Our Ref: FP/56/18/HH
Your Ref:

Town & Country Planning Act 1990 (as amended)
Town & country Planning (Development Management Procedure) (England) Order 2015
Application for Planning Permission for Works or Extension to a Dwelling

Development Single storey rear extension to existing house & single storey side extension to existing detached garage. This application may affect the setting of listed buildings & affects the character & appearance of the Felpham Conservation Area.

Location The Gate House Manor Copse Felpham

PROPOSED BLOCK PLAN | 1:200@A3

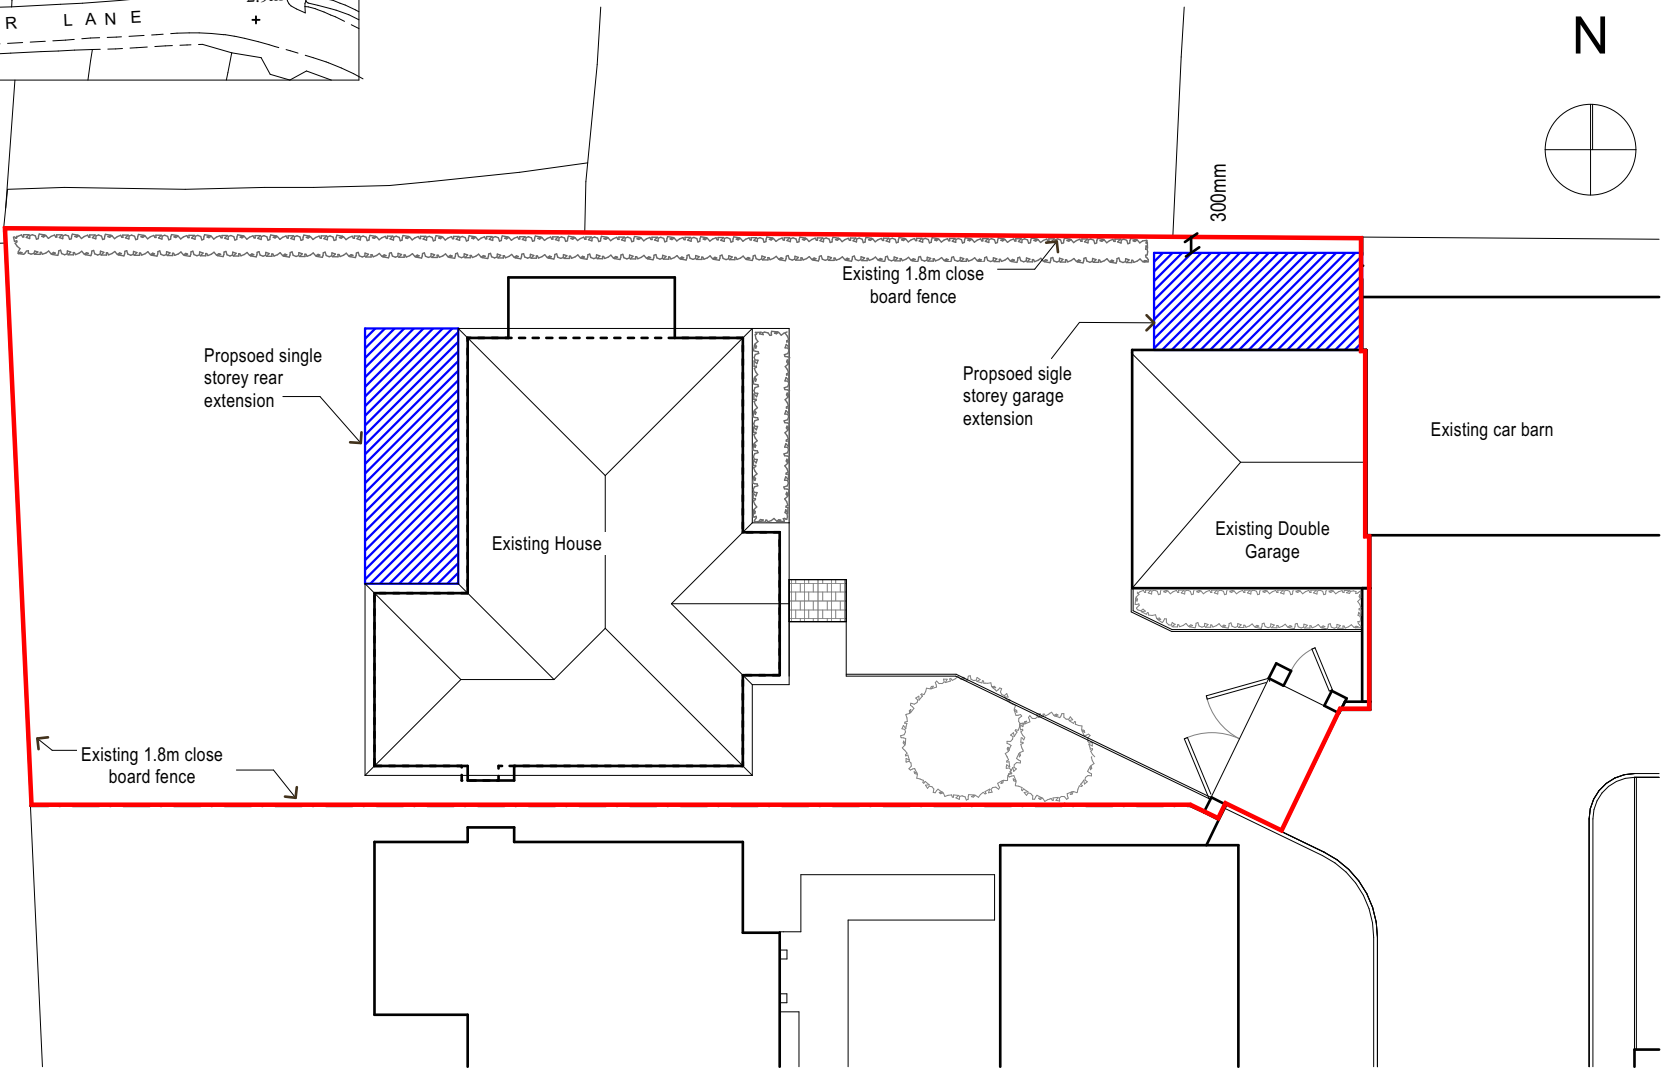
Block Plan Amend

Please submit 1 electronic or 3 paper copies of a block/site plan at a scale of 1:500 or 1:200. Further details of what must be included on the plan can be found in the National Validation Requirements. Please provide a measurement from the proposed side garage extension to the side site boundary.

PROPOSED EAST ELEVATION | 1:100@A3

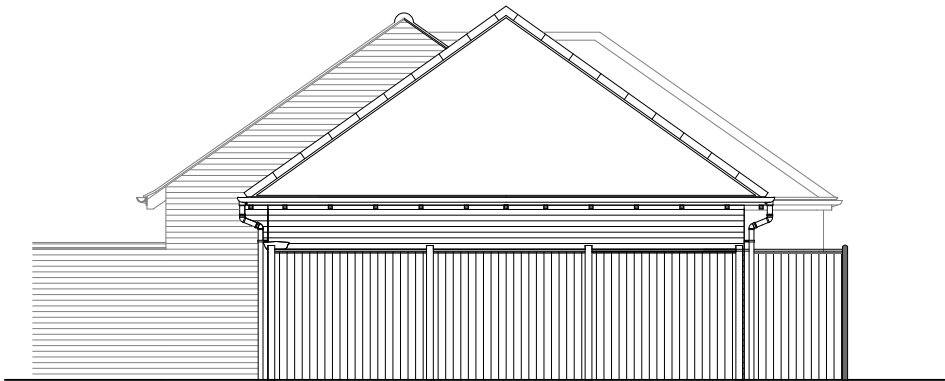
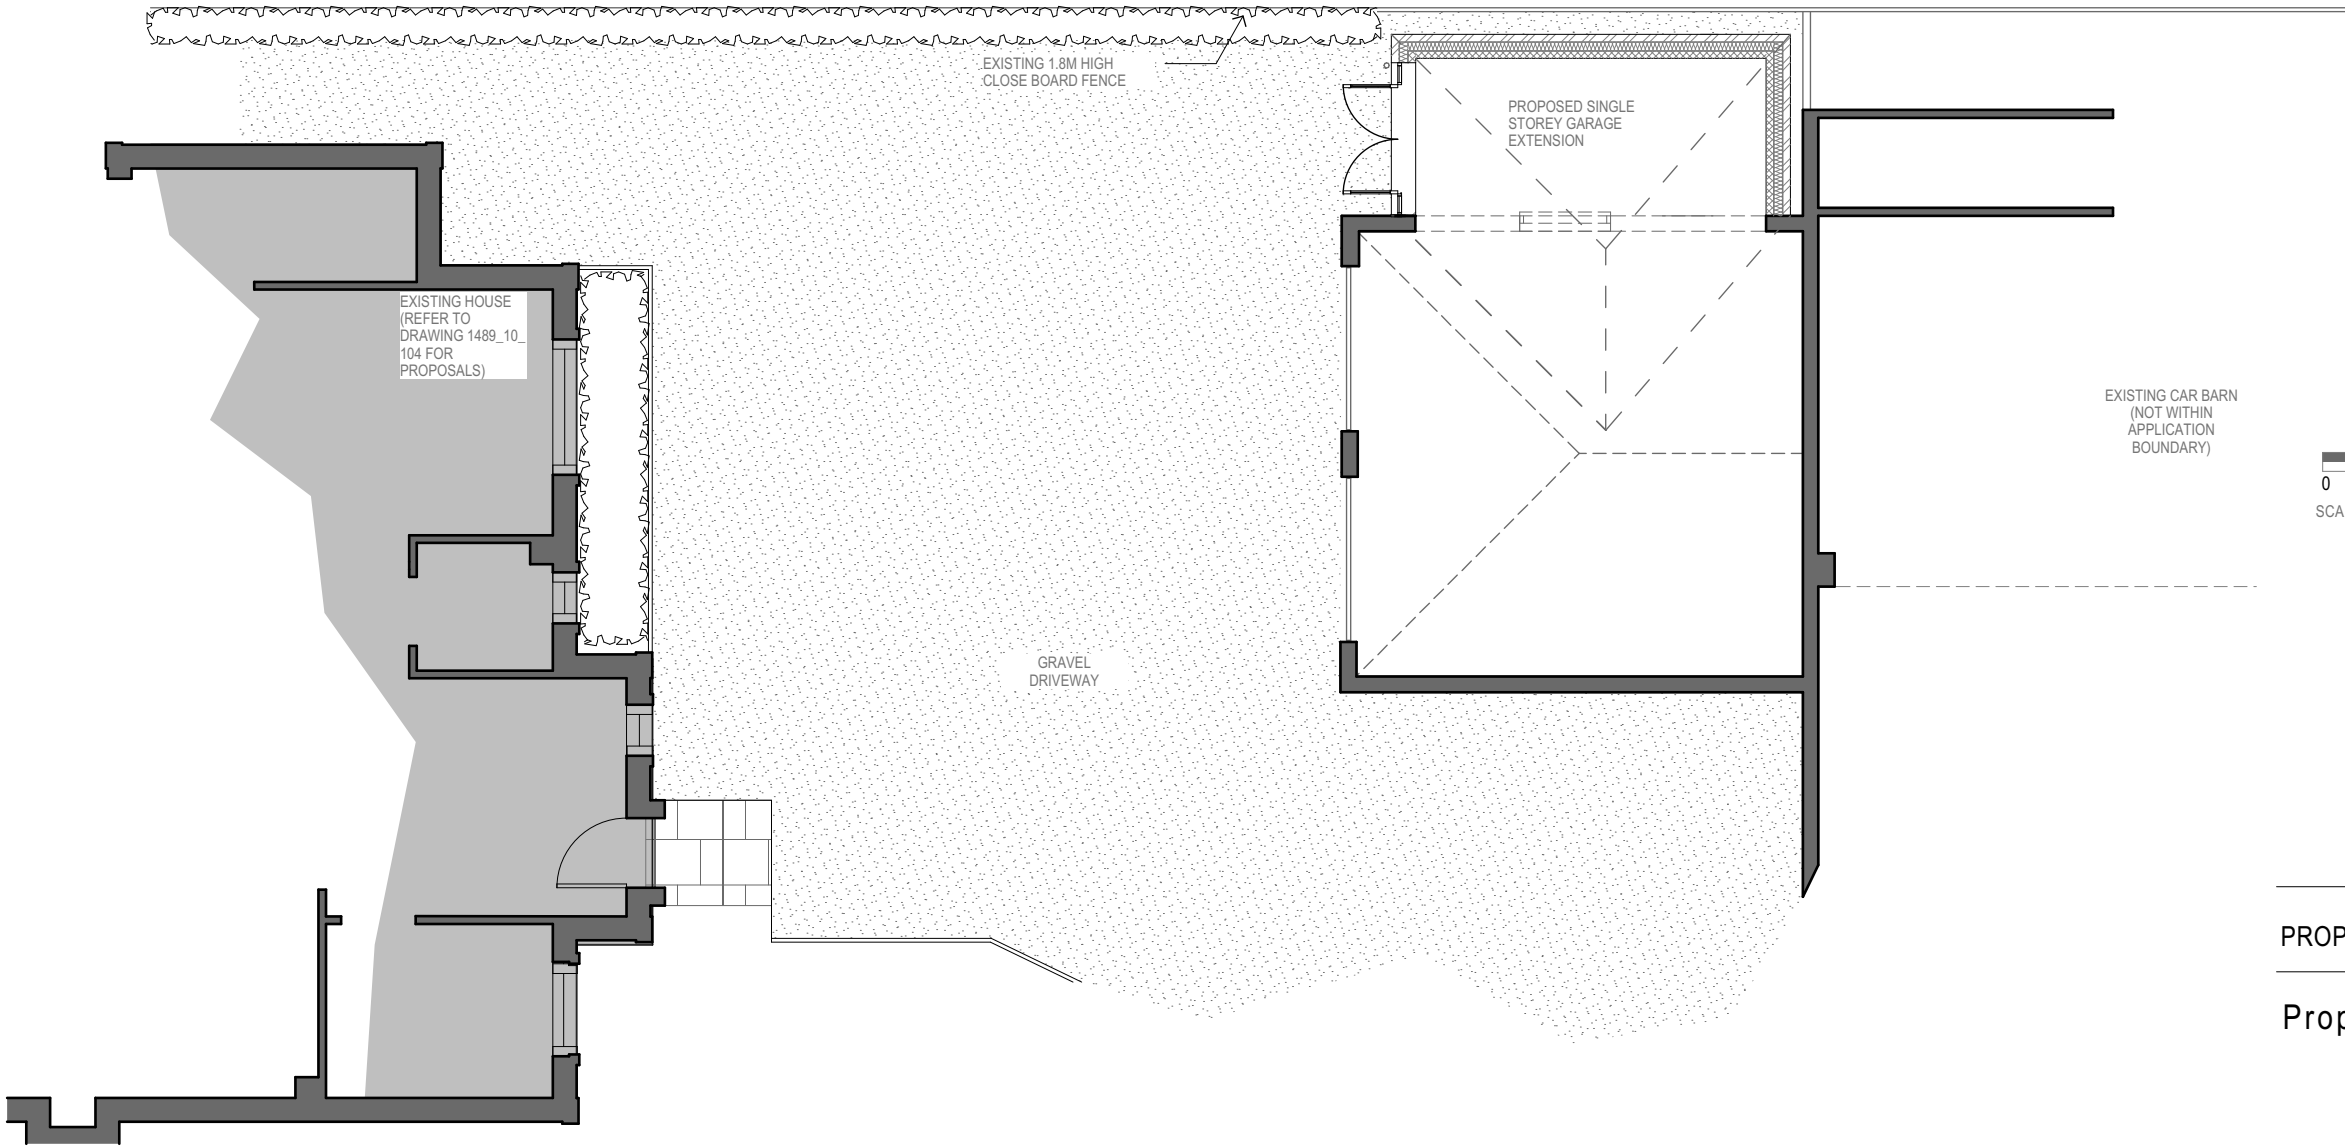
Please provide a proposed east elevation for the garage.
